From: Anita Gardner
Sent: 25 June 2019 11:20
To: Planning.Responses
Subject: FW: F/30/18/PL - Multispan polytunnels at Wicks Farm.

Subject: RE: F/30/18/PL - Multispan polytunnels at Wicks Farm.

Title
CONSTRUCTION DETAILS

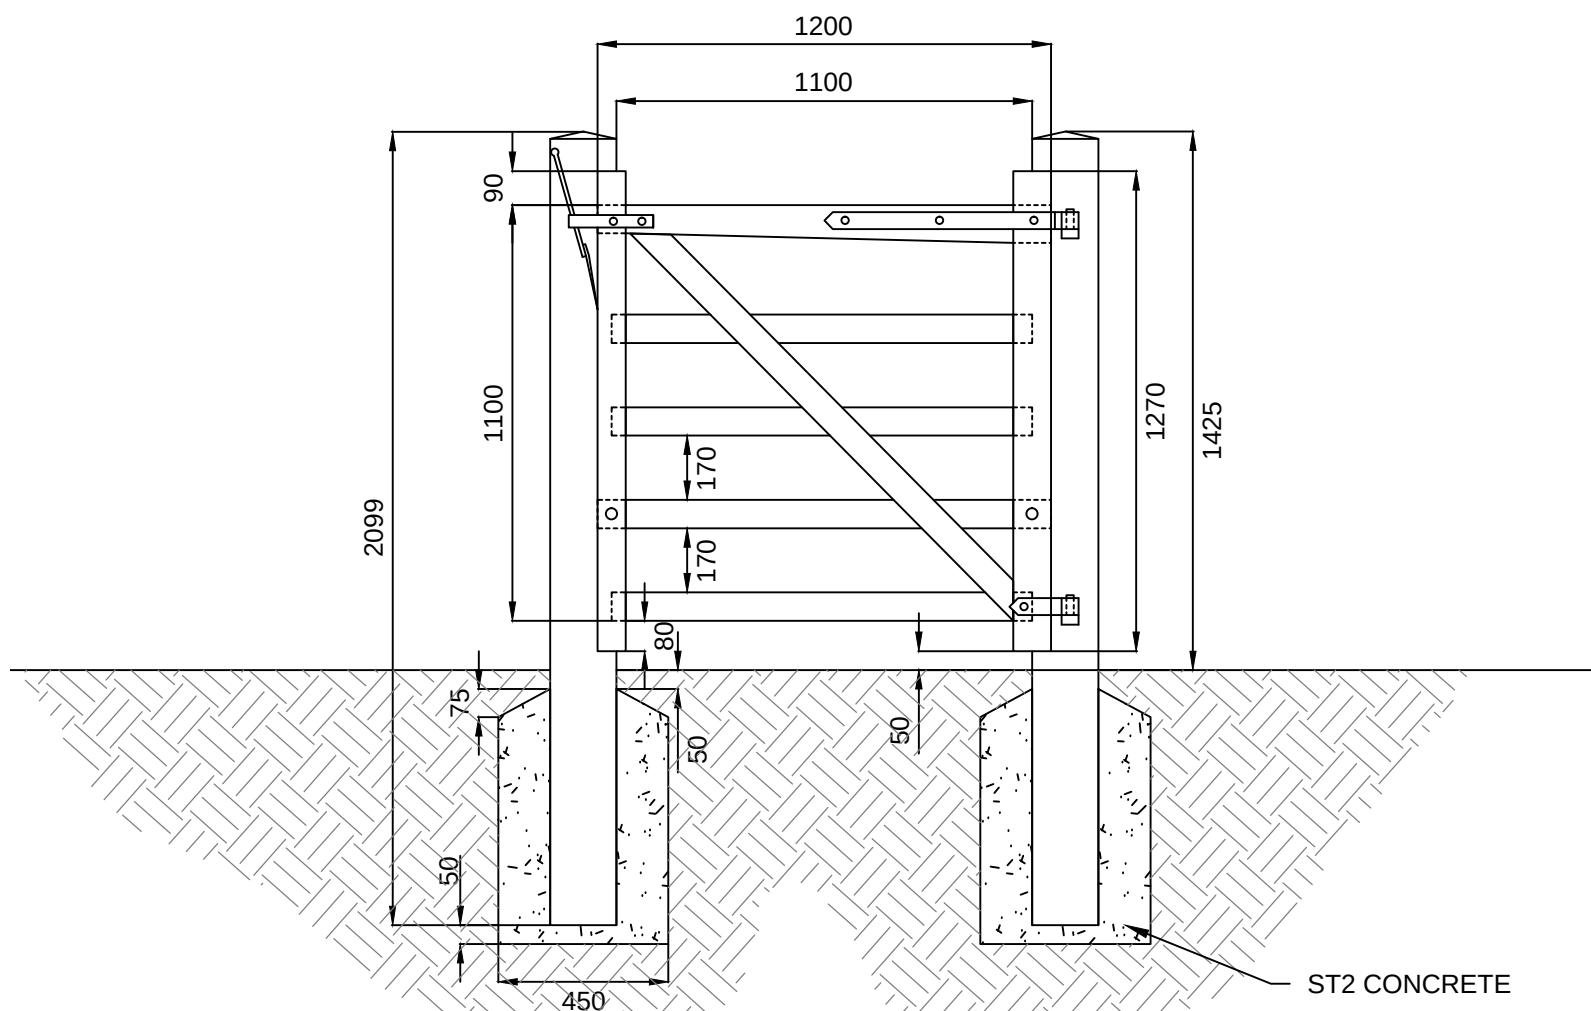
- c) Demonstrate drainage systems to protect the PROW.
The drainage systems from the roofs of the multispan polytunnels are designed to drain directly to the main reservoir to the North. No drainage water from the site will be directed towards the PROW.
